COMMENT BY CITY OF SYDNEY, 10 MARCH 2011,

PROPOSED SUPER YACHT FACILITY, (MP 09_0165)

Figure 2-1: Site Aerial and Locality

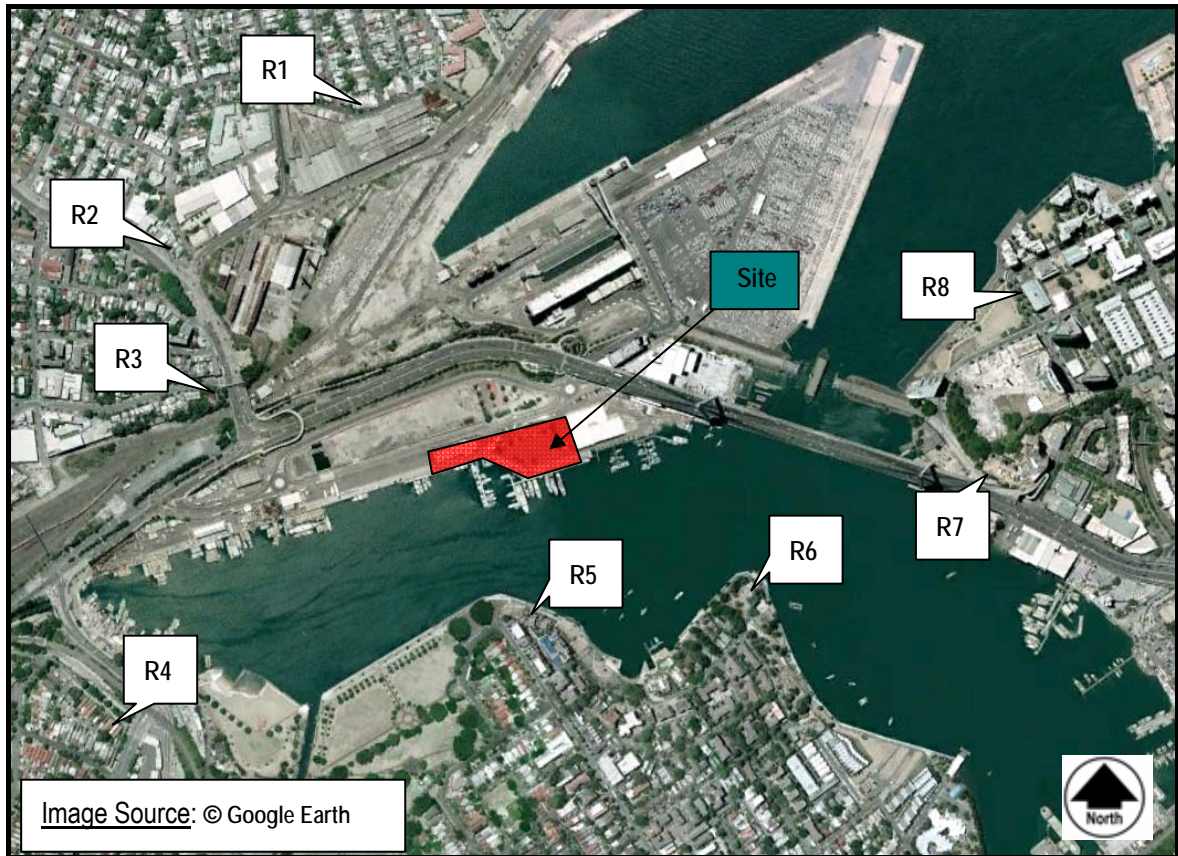
3. The inclusion of a scale map showing where the measurements were taken would have been useful, if not essential. It is notable that the 2003 background measurements presented do not include measurements made at the nearest residences (at Glebe Point/Federal Road) to the proposed development even though later in the report it is clear that the Glebe Point residences are the ones that will be most affected by the noise emanating from the marina facilities.
